August 20, 2013

Re: HME Specialists Office/Retail, Grading and Drainage Plan
Engineer's Stamp Date 7-15-13 (A12D008C)

Based upon the information provided in your submittal received 7-16-13, the above referenced plan cannot be approved for Building Permit until the following comments are addressed:

GRADING PLAN

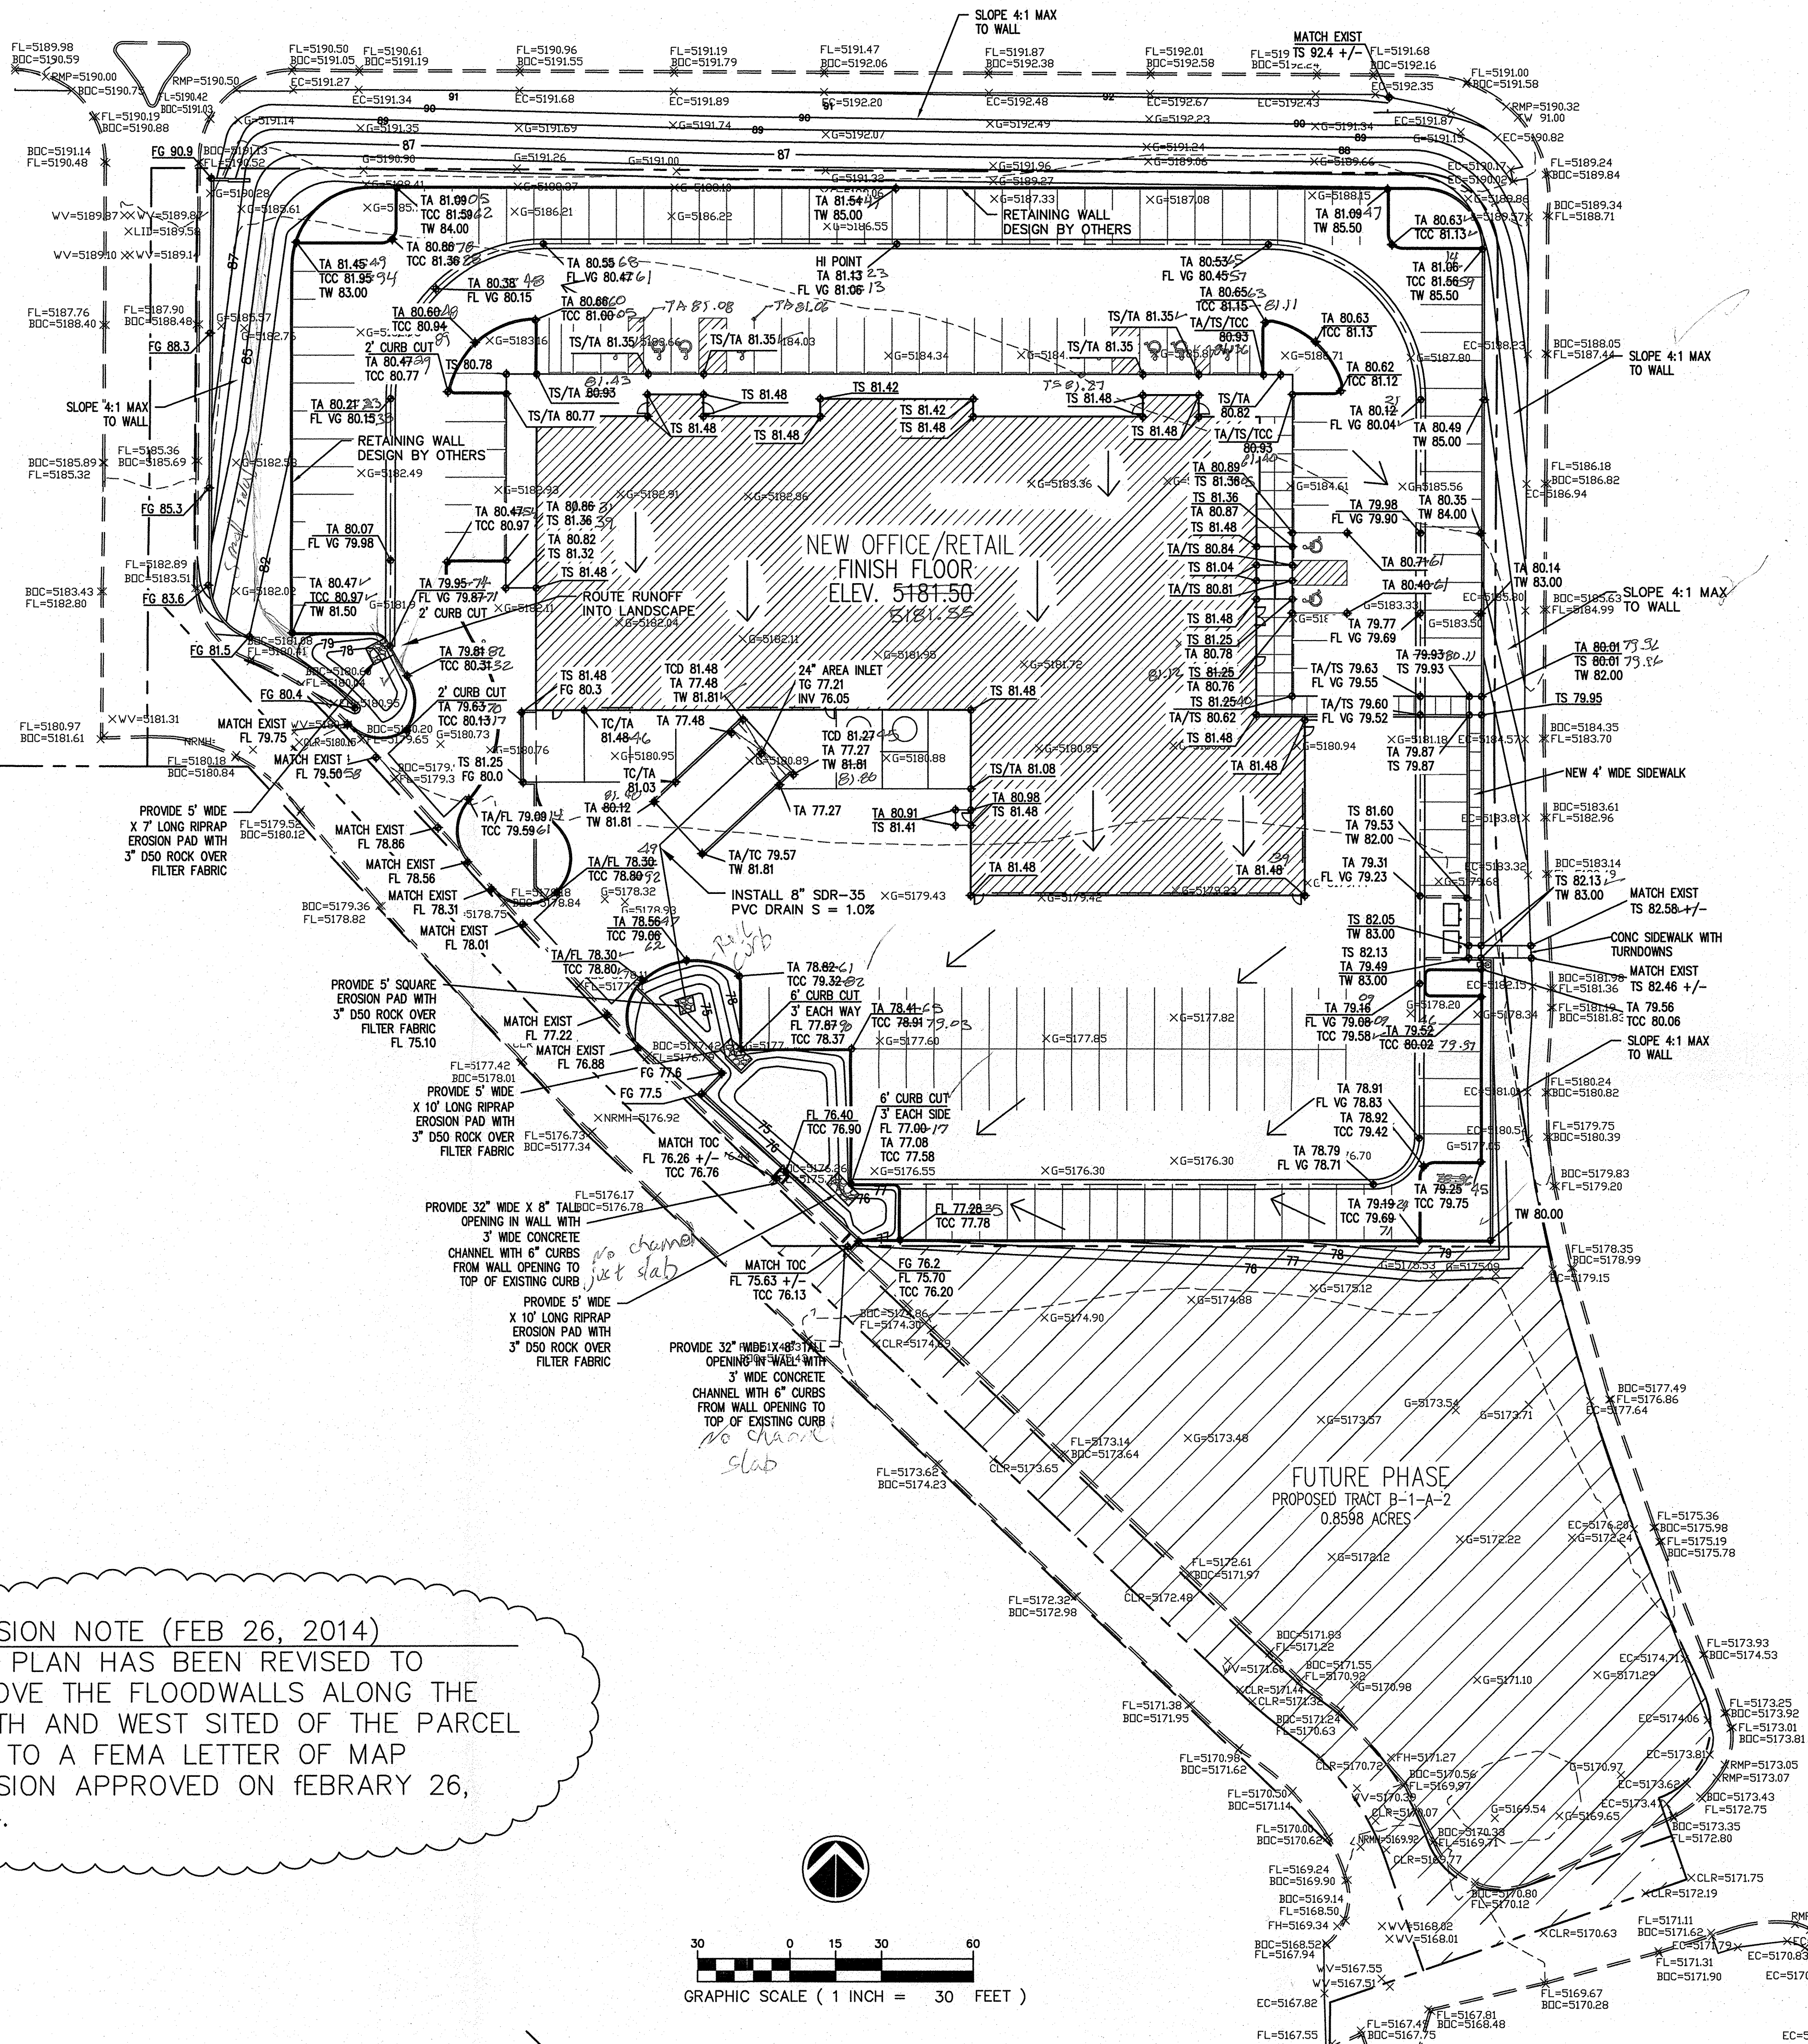
8. If the floodwall on top of the retaining wall or is it one wall with a consistent section?
9. Submit the floodwall design and required calculations for Hydrodynamic Force and Debris Impact Force.

DRAINAGE REPORT

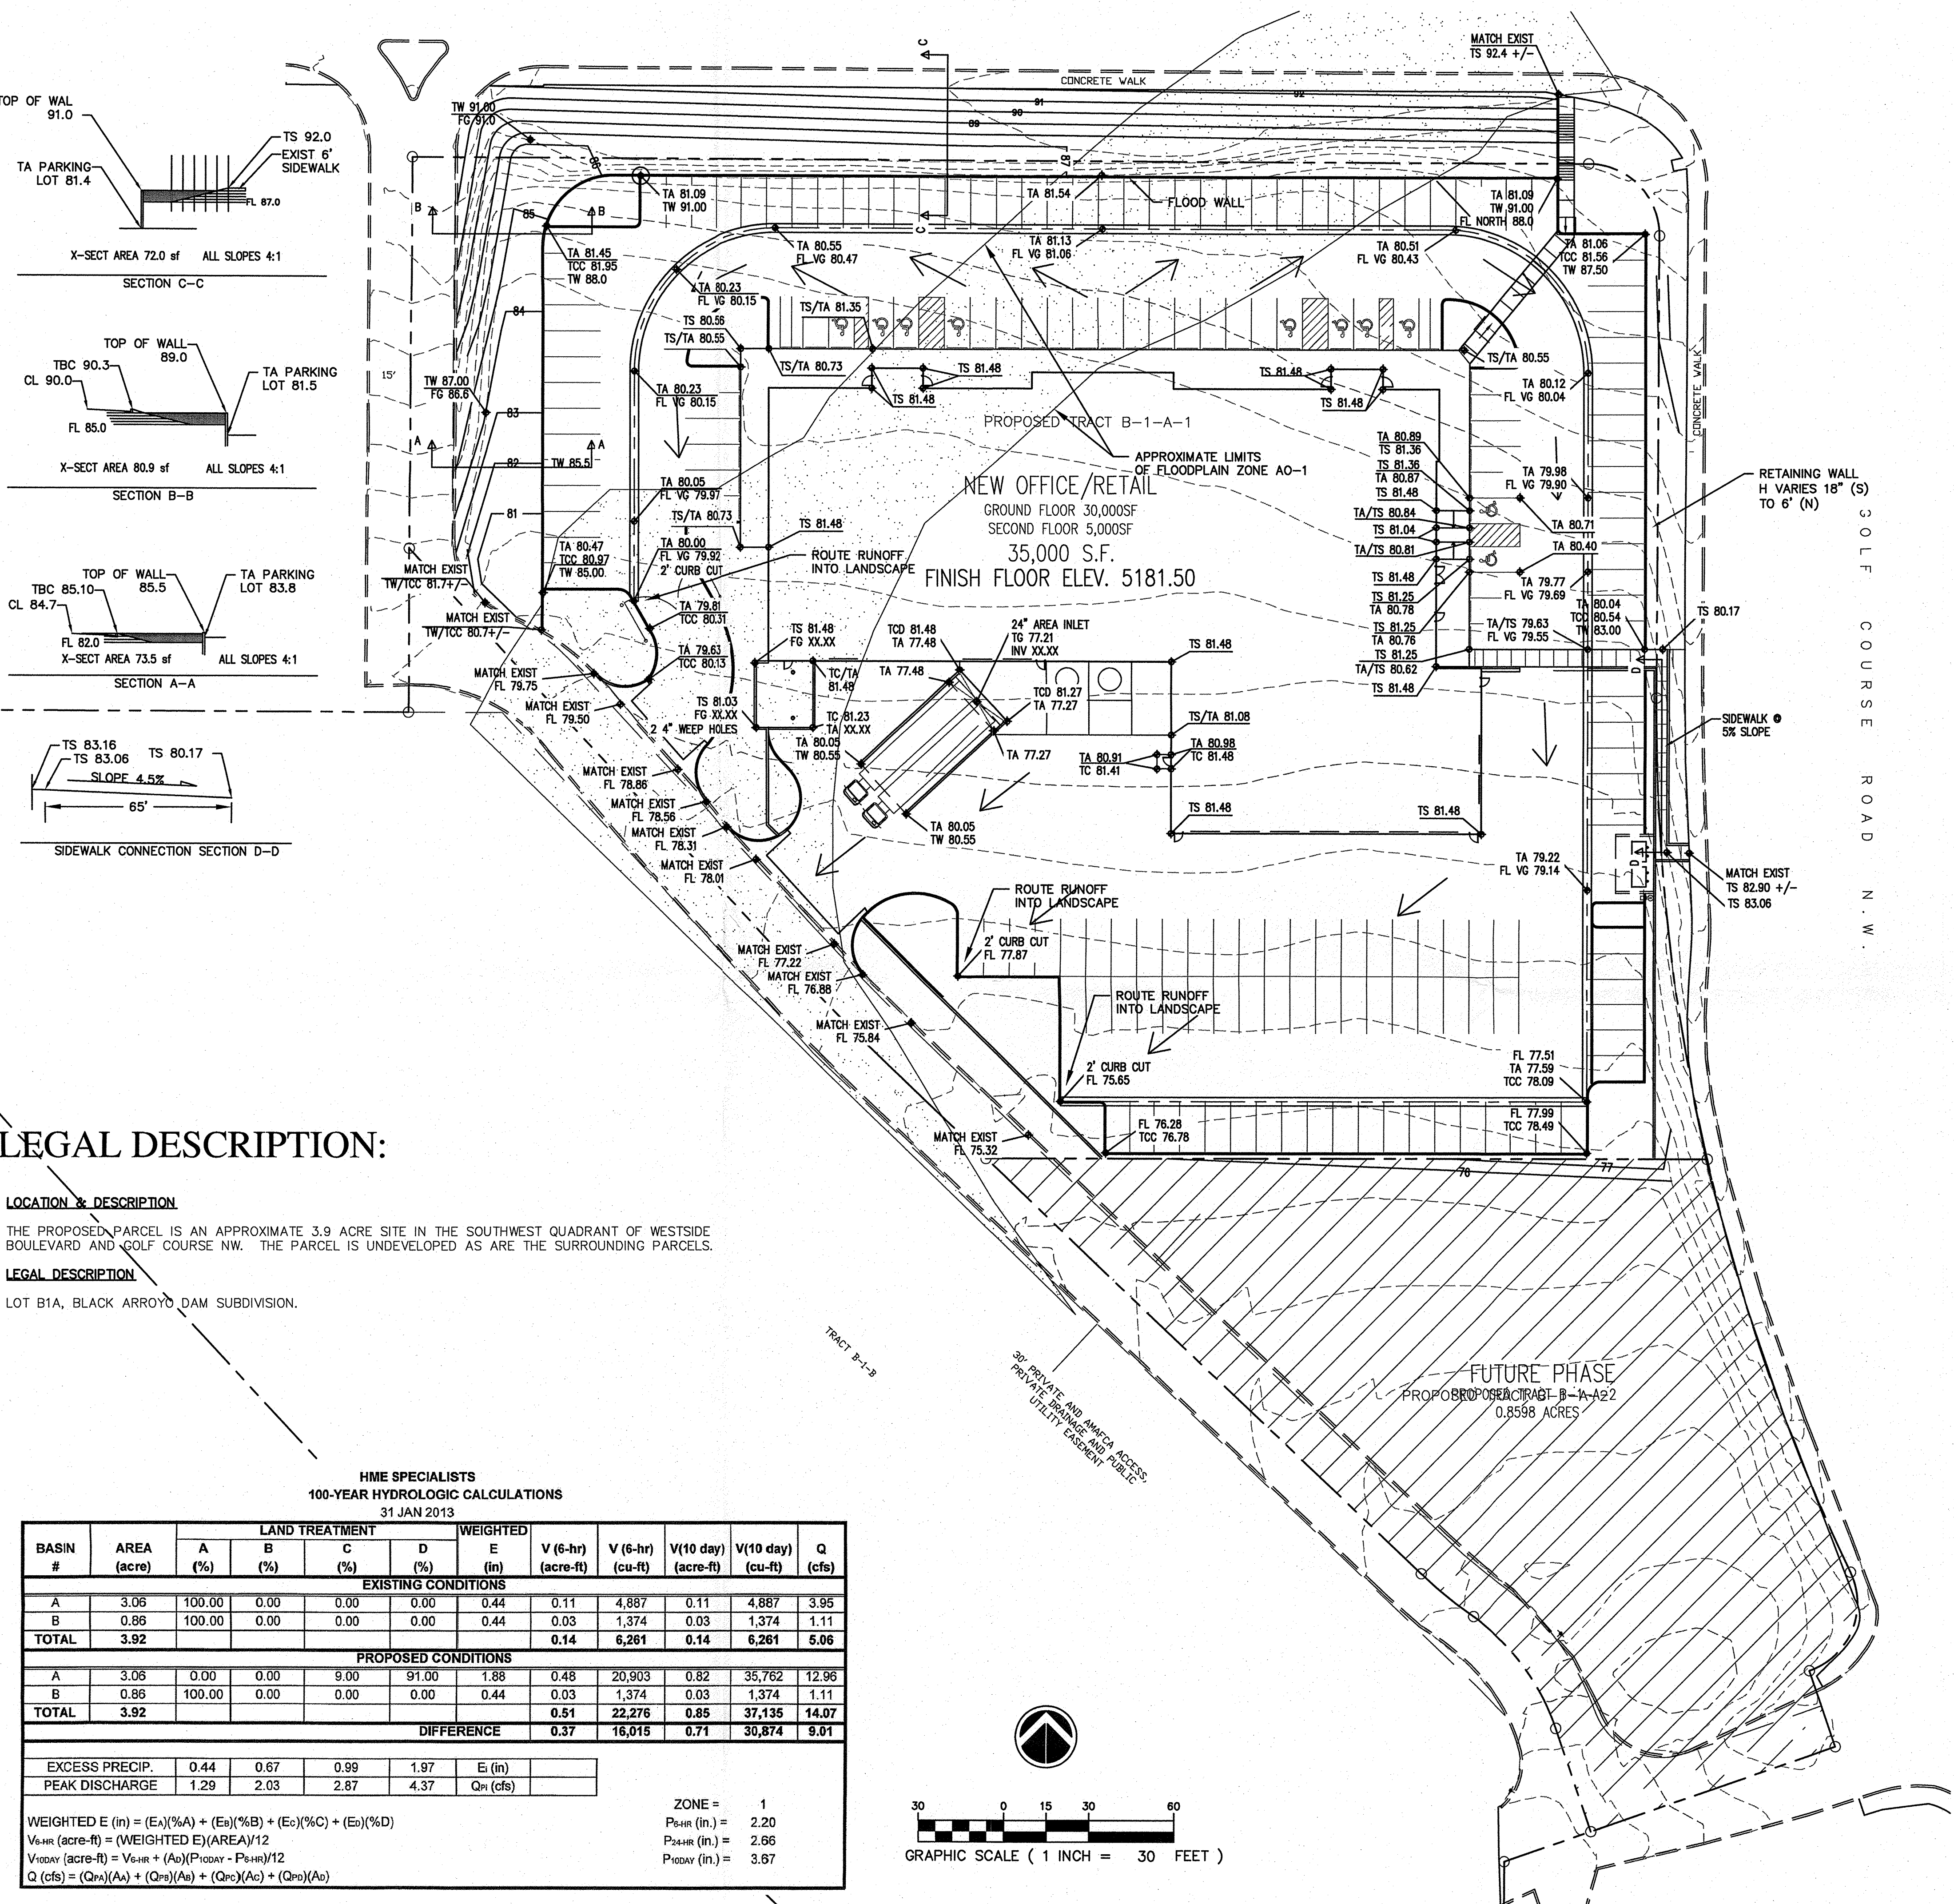
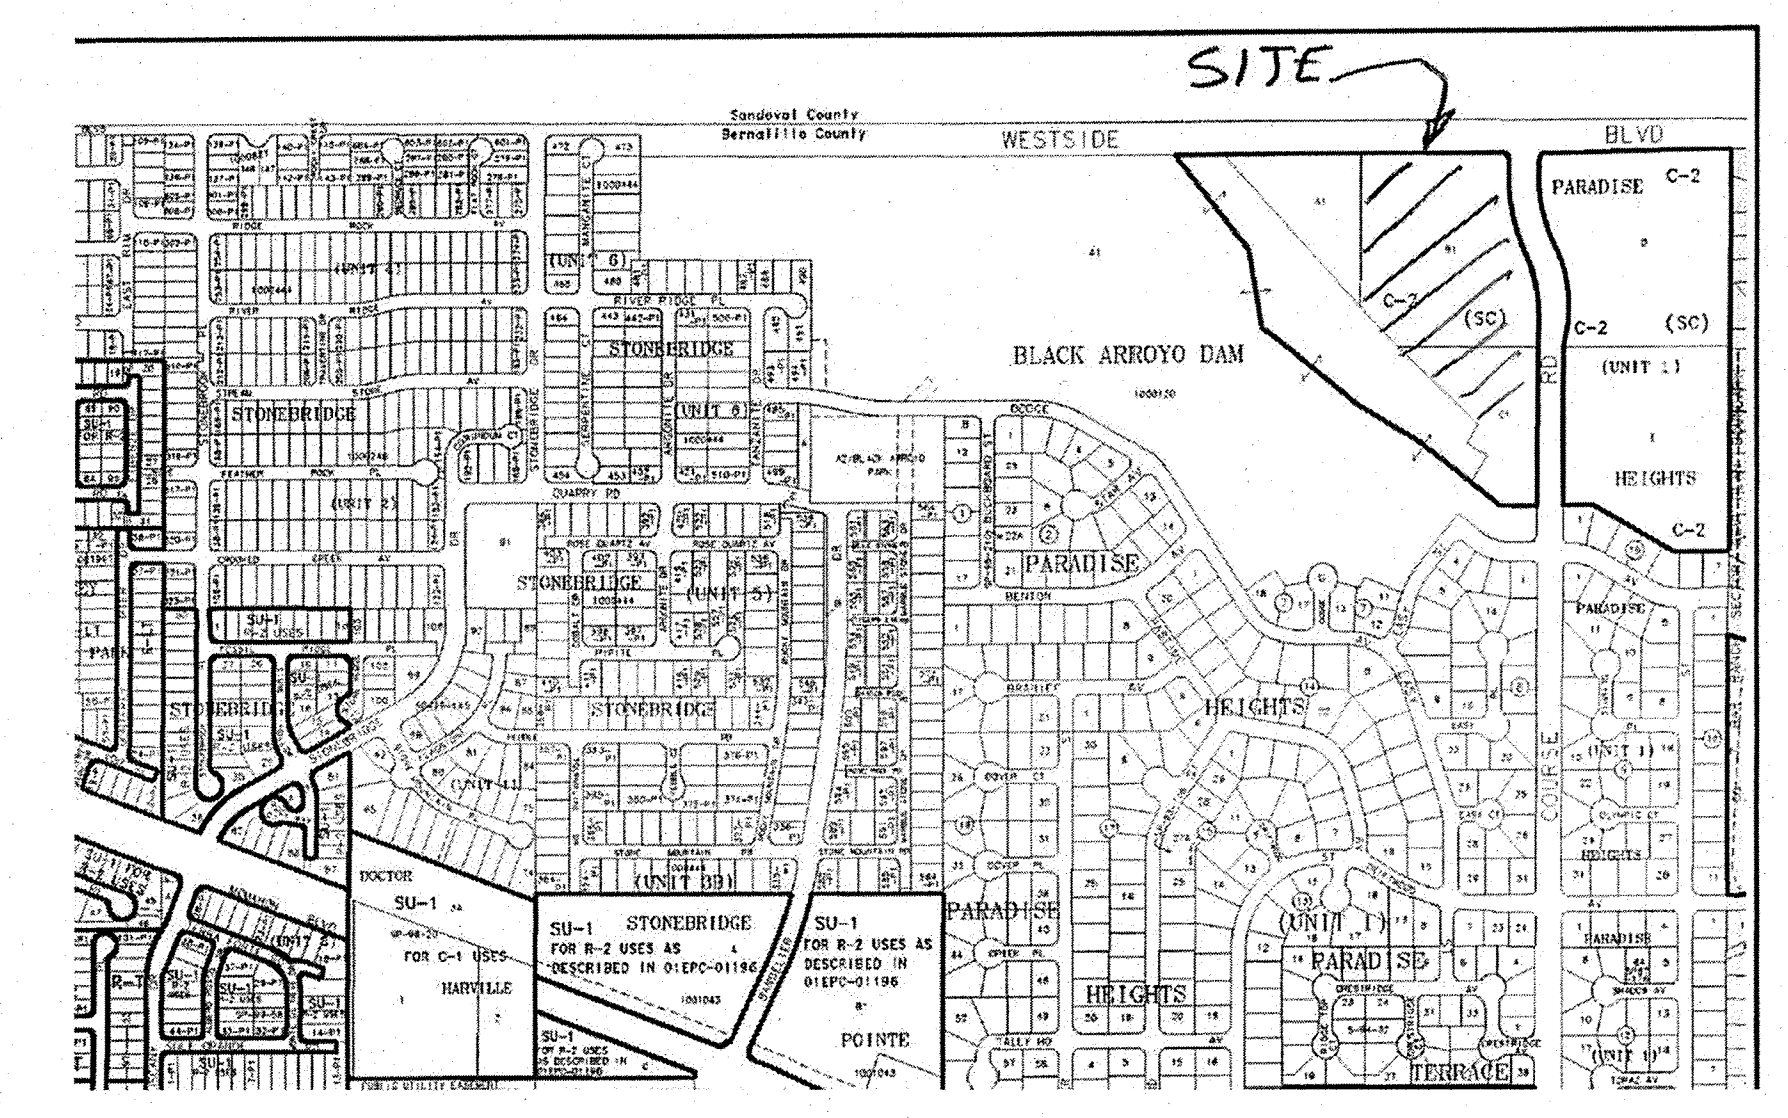
1. Stairs should not be proposed in the City ROW, because Street Maintenance does not want to maintain them. Hydrology suggests you remove the stairs with an Administrative Amendment to the Site Plan. Transportation does not require a connection to Westside Blvd.

2. Provide Sections A-A, B-B and C-C as were provided on the conceptual plan submitted for Site Plan approval at DRB.
3. The plan proposed grading on the lot to the south. The site to the south may choose to cut in this area similar to this site. A retaining wall should be considered or written approval from the owner of the lot to the south is required.

4. Provide the direction of roof flows. It is difficult to tell how much flow will be draining towards the landscape area in the southwest corner and whether 2' curb cuts will be large enough.

5. Flows that enter the landscape area in the southwest corner should drain to the private road rather than to the property to the south. Possibly continuing the 76 contour close to the curb would help.

6. The proposed loading dock drain line would require a section of curb on the private road to be removed. Should the line daylight before the curb?
7. It appears the grade on the sidewalk connection to Golf Course Blvd should be higher where it turns south. The existing grade is approximately 83.5 and the proposed TS is 80.17.

10. Please show the correct FIRM Panel.
